**Planning Department
Transportation Development Services**

**Re: TLC Pet and Uptown Cat Hospitals, 1300 Wyoming Boulevard, N.E.
Traffic Circulation Layout**
Engineer's/Architect's Stamp dated 10-06-14 (J20-D027)

Based upon the information provided in your submittal received 10-07-14, the above referenced plan cannot be approved for Building Permit until the following comments are addressed:

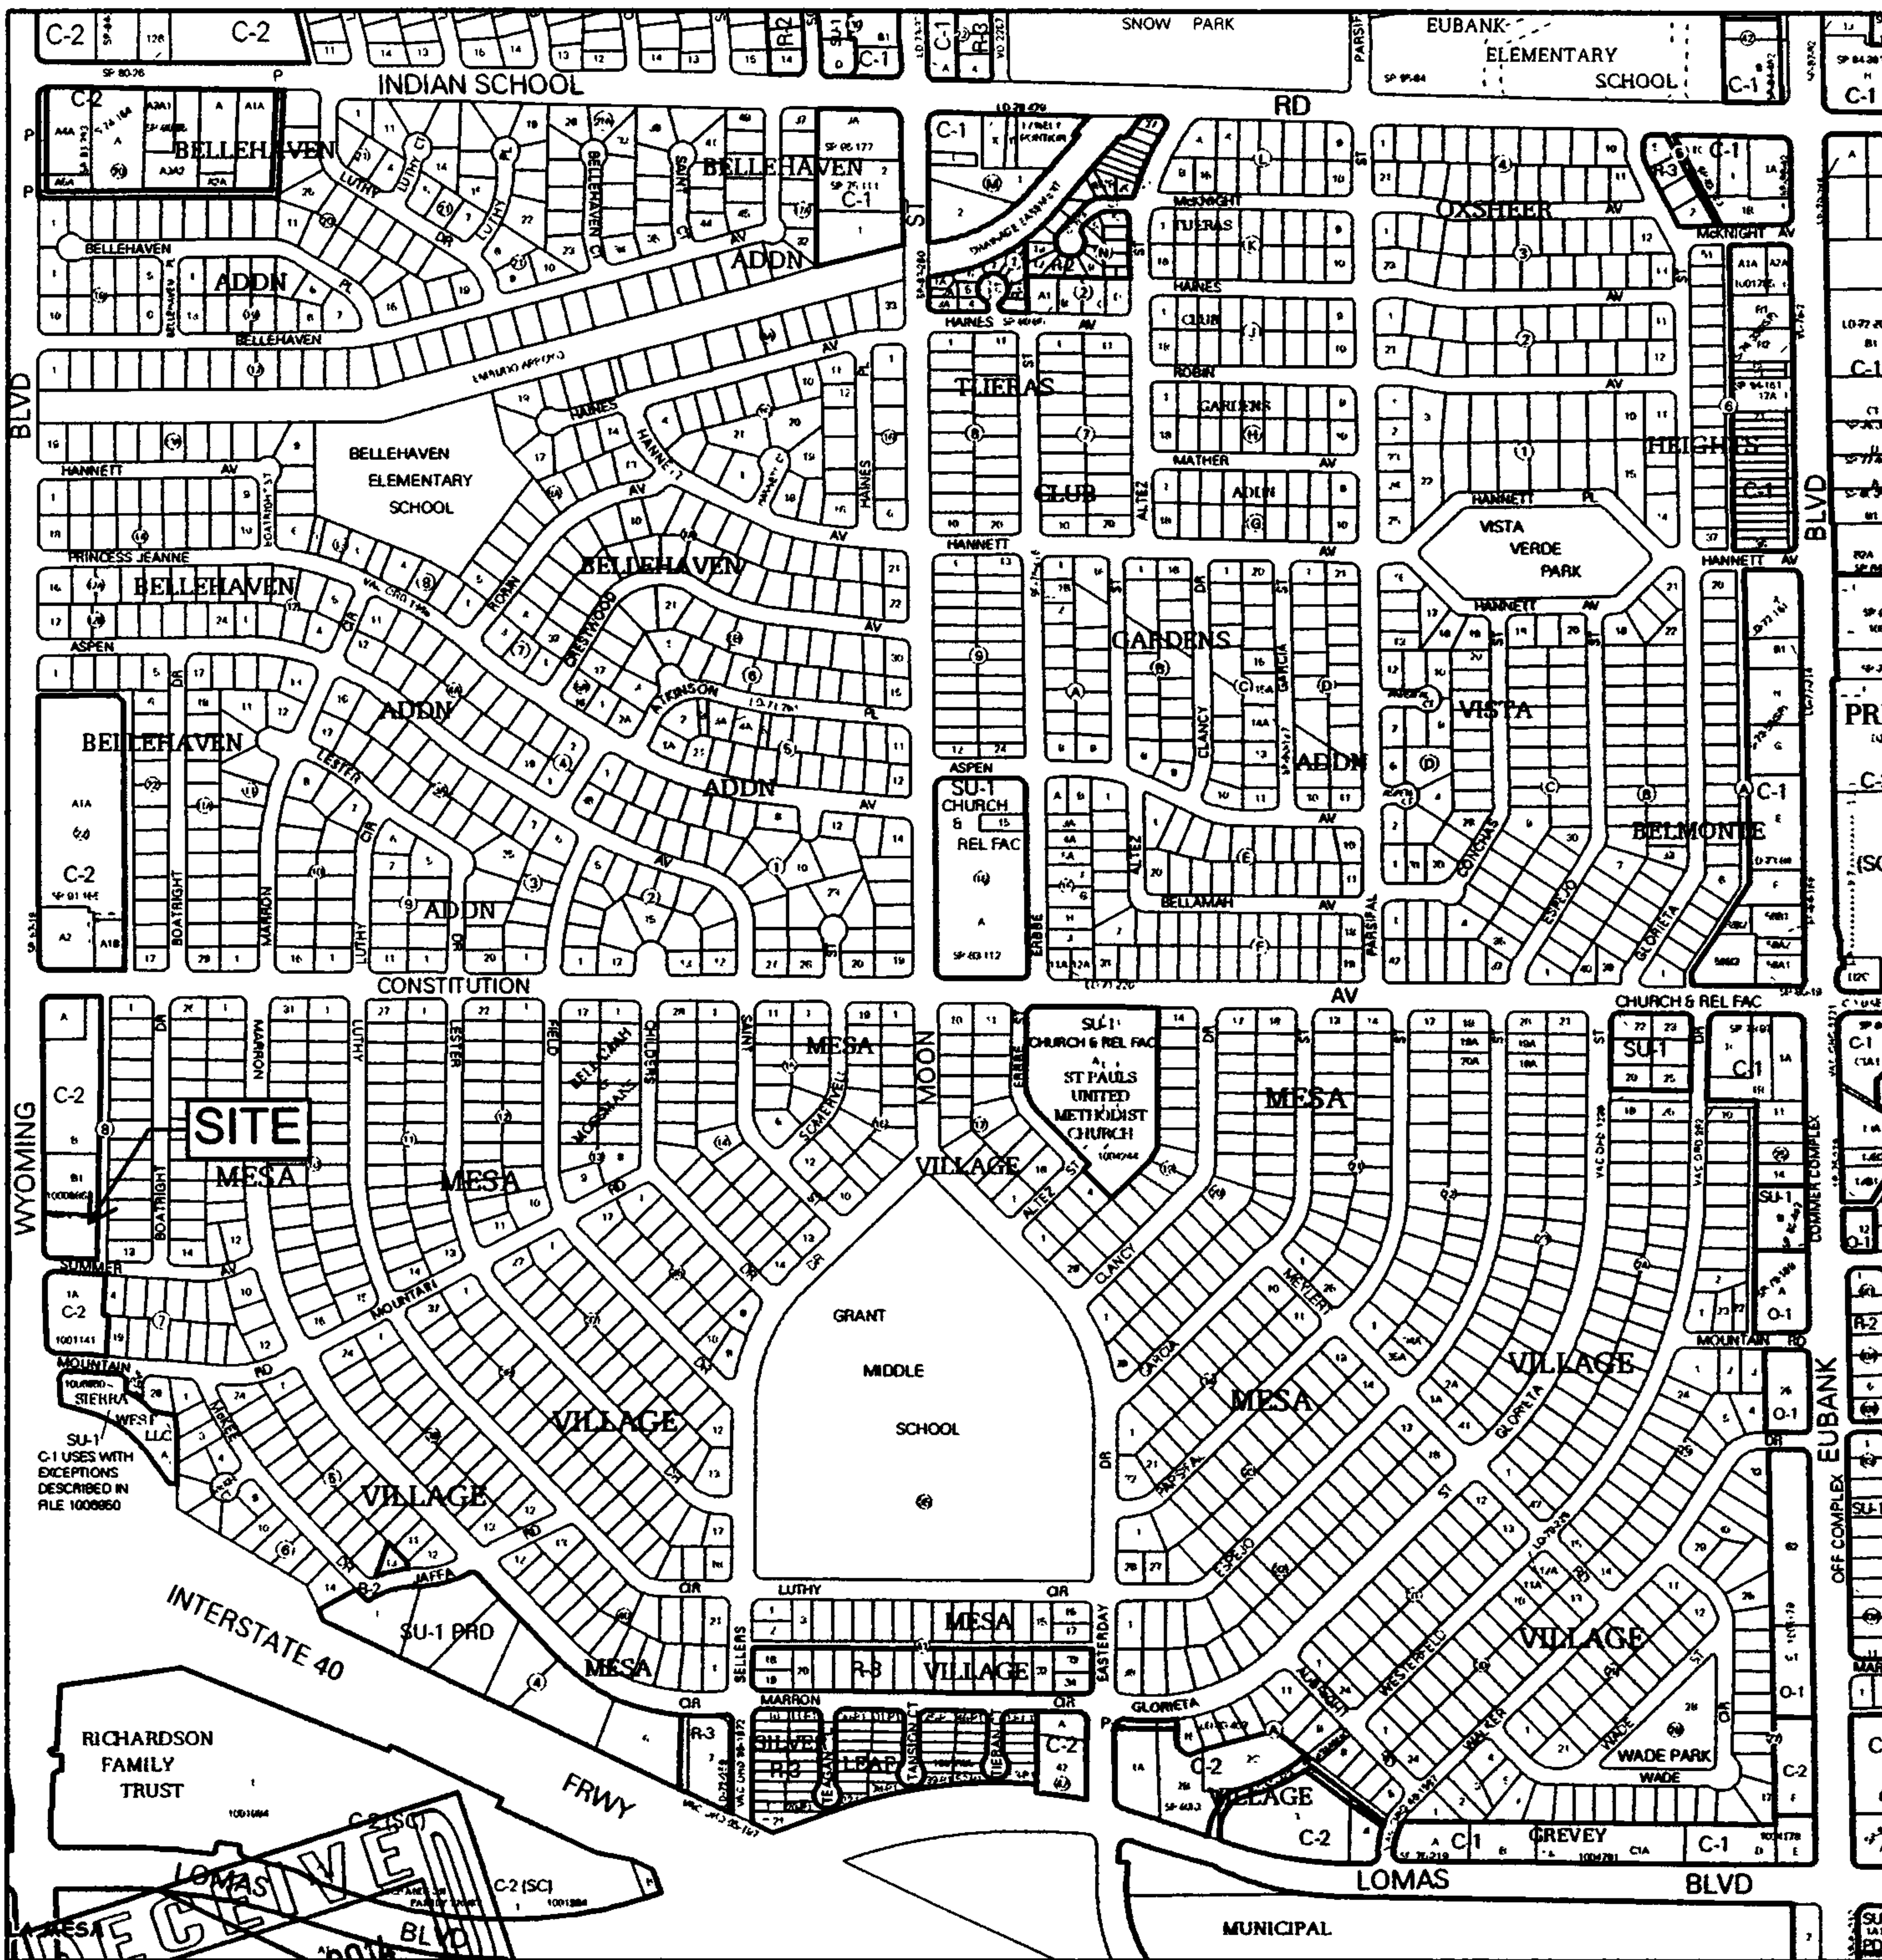
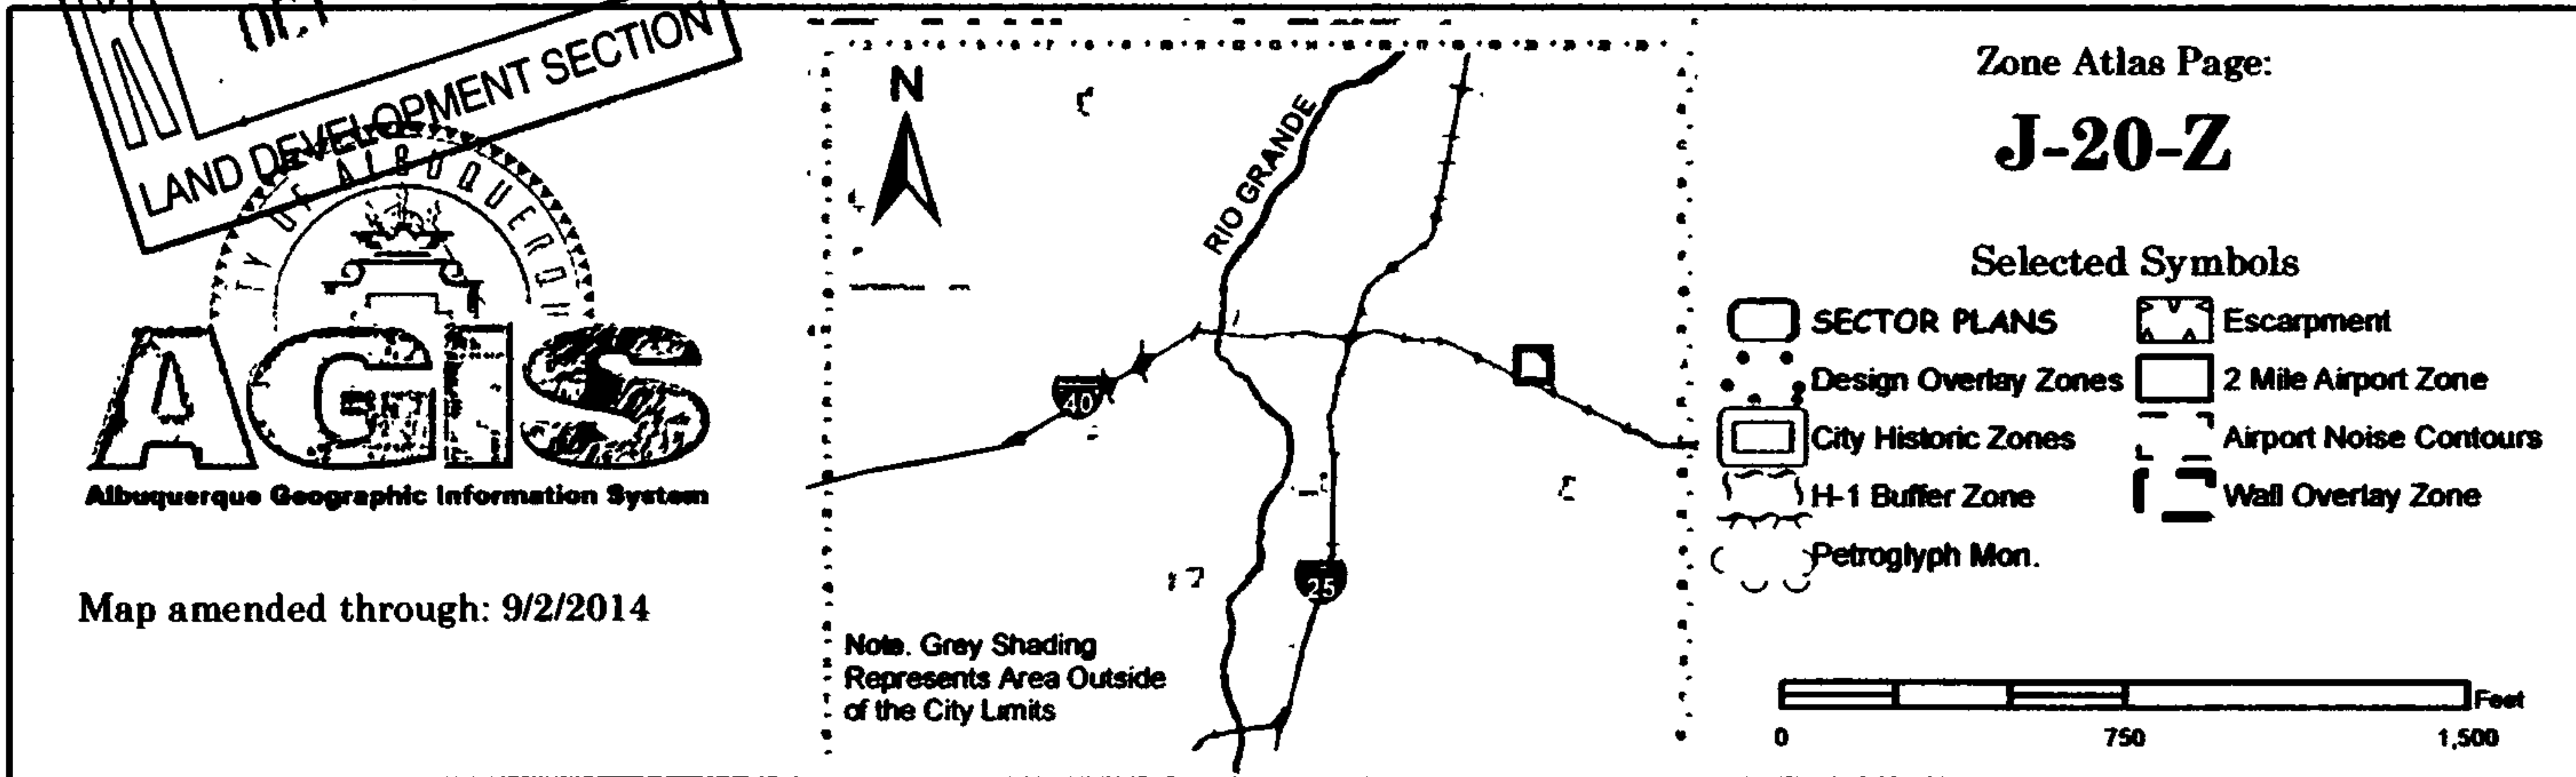
1. Please provide a vicinity map with the location of the site development in relation to surrounding streets.
2. Please provide a legend for the various line-types and hatching.

3. Identify the existing right-of-way width, medians, and street widths for Wyoming Boulevard and Summer Avenue.
4. In addition to being too close to the Summer Avenue intersection, the existing drivepad on Wyoming Boulevard does not match up with the driving aisle. Revise the existing drivepad to match up with the driving aisle along the south side of the access.

5. On the southwest corner of the parking lot, make a correction from "3 Spaces @9'-0" = 18' " to " 2 Spaces@9'-0" =18' ".
6. For Keyed Note 16, the ADA van accessible sign must have the required language per 66-7-352.4C NMSA 1978 **"Violators Are Subject to a Fine and/or Towing."**

7. The ADA access aisle shall have the words **"NO PARKING"** in capital letters, each of which shall be at least one foot high and at least two inches wide, placed at the rear of the parking space so as to be close to where an adjacent vehicle's rear tire would be placed. (66-1-4.1.B NMSA 1978)

8. See Figure 23.7.2 of the DPM for end of parking aisle islands. Change the curb radii from 1 foot to 3 feet where shown on parking aisle islands near the end of

the parking spaces. Curb radii should be 15 feet for passenger vehicle maneuvering.

9. Graphically, it appears that it will be difficult to incorporate a 6-foot wide flat ADA-accessible path in front of the door in addition to a ramp with a 12:1 slope. (Make sure that both the 12:1 ramp and a 6-foot pathway can be incorporated. The ramp is only drawn at a 5-foot length.)

10. Call out curb height for Keyed Note 12. Keyed Note 12 needs to correctly point to curb for access off of Wyoming Boulevard.
11. For ease of refuse vehicle maneuvering, move the refuse at least a few feet to the east away from the curb.

12. Indicate what pavement thickness will be used for the parking lot.
13. The proposed landscaping at the access off of Summer Avenue may interfere with the sight distance. Provide clear site triangle. (See DPM Manual Page 23-74 of the DPM for Mini Clear Site Triangles for Driveways.)

14. Please add the following note to the clear sight triangle: "Landscaping and signage will not interfere with clear sight requirements. Therefore, signs, walls, trees, and shrubbery between 3 and 8 feet tall (as measured from the gutter pan) will not be acceptable in this area."

15. Please specify the City Standard Drawing Number when applicable.
16. Work within the public right of way requires a work order with DRC approved plans.
